Wagga Wagga Hospital Redevelopment - Stage 3 – Modification 5 (SSD-9033-Mod-5) Request for additional information

This response has been prepared by Ethos Urban on behalf of Health Infrastructure NSW (Health Infrastructure) regarding your letter dated 6 May 2021 seeking additional information regarding the above modification application. A response to your queries is provided in the table below.

ARCHITECTURAL SERVICES
SITE PLAN - PROPOSED

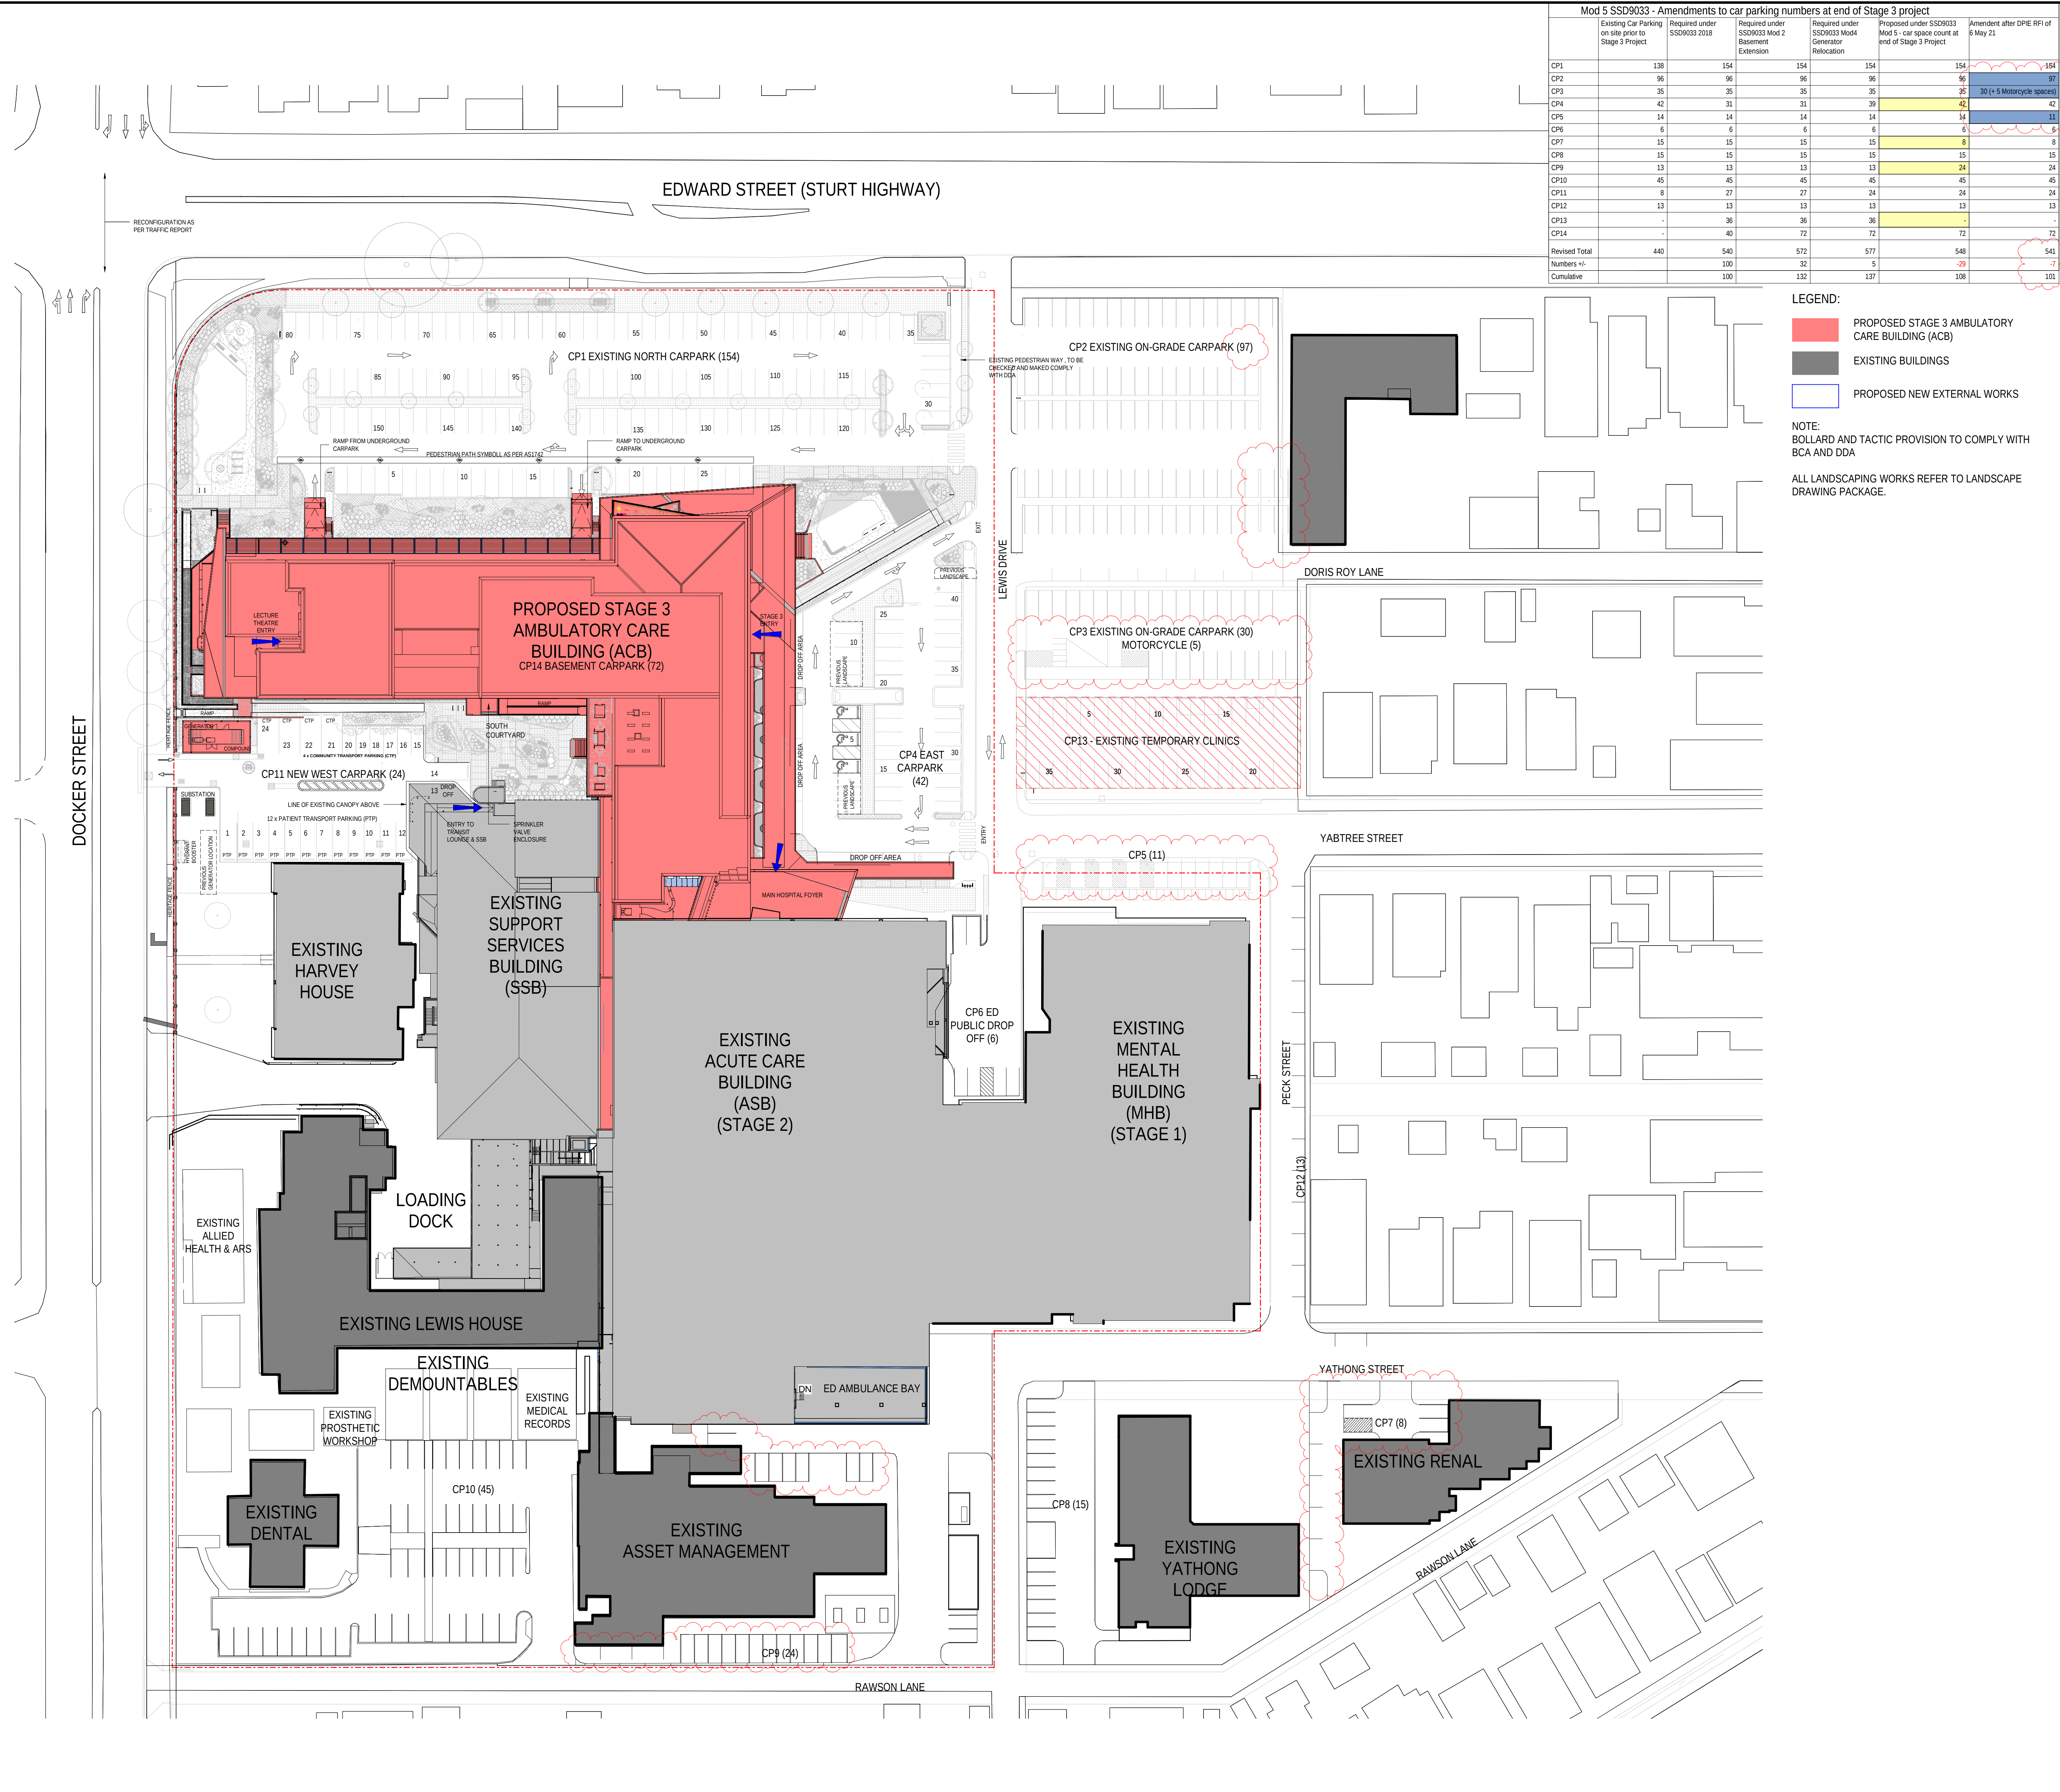
Request	Response
Table 3 in the modification report identifies 14 car spaces available within Carpark 5, however it appears from aerial photography of the site that only 11 spaces have been provided.	A detailed reconciliation of car parking has been carried out across the campus and amendments have been made to the Architectural Plans that are provided at Appendix A , Refer to Table 2 below for changes to parking to reflect the on-site parking supply.
the modification proposes to include 24 spaces located in Carpark 9, but it is unclear where these will be located from the amended site plan and aerial photography of the site.	
the modification proposes to include eight car spaces located in Carpark 7, but it is unclear where these will be provided. The amended site plan is to be updated to show the stated eight available spaces.	
the current layout of Carpark 3 is to be shown on the amended site plan (including the seven available parallel spaces on Doris Roy Lane, motorcycle parking and yellow hatched areas within CP3 where car parking is no longer available).

Architectural Plans prepared by Jacobs			
Drawing Number	Revision	Name of Plan	Date
IA172202-ACB-RB-DRG-0100	P 10	Site Plan – Proposed	28/04/2020 12/05/2021
IA172202-ACB-RB-DRG-0110	4	SITE PLAN - CARPARKING - CP4	12/05/2021
